**Jeanie Bourke - Re: 173 Pleasant Ave., BP#2015-00440 plan review comments**

**From:** John Hatzenbuehler <ndhatz@gmail.com>  
**To:** Jeanie Bourke <JMB@portlandmaine.gov>  
**Date:** 5/12/2015 2:04 PM  
**Subject:** Re: 173 Pleasant Ave., BP#2015-00440 plan review comments

SKETCH: A2

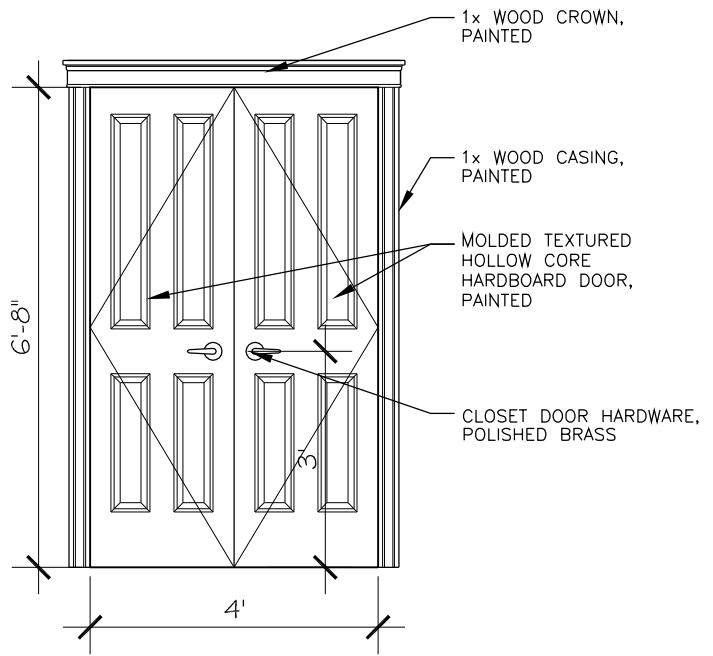
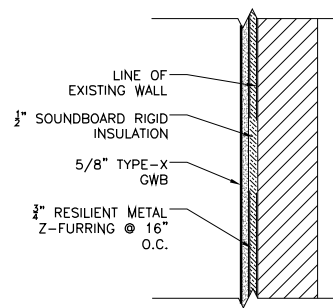
Just to be clear, what do you mean by congruently on all adjoining walls and ceiling? For example, will not only the adjoining unit wall, but, all partitions in the unit with the dwelling above have 5/8 type X drywall over the top plate to form a continuous ceiling membrane?

Do I understand your description correctly? Short of revising the diagram of the head of wall, this needs to be clear in order to approve it.

I also just left you a voice message just in case. Yes, you understood my description correctly. The adjoining unit wall, and all partitions in the unit with the dwelling above will have 5/8 type X drywall over the top plate to form a continuous ceiling membrane.

We've decided we will run type X drywall congruently on all adjoining walls and ceiling for the fire separation required in the code. is that something I need to add to the files or can you do that for me on the permitting paperwork.
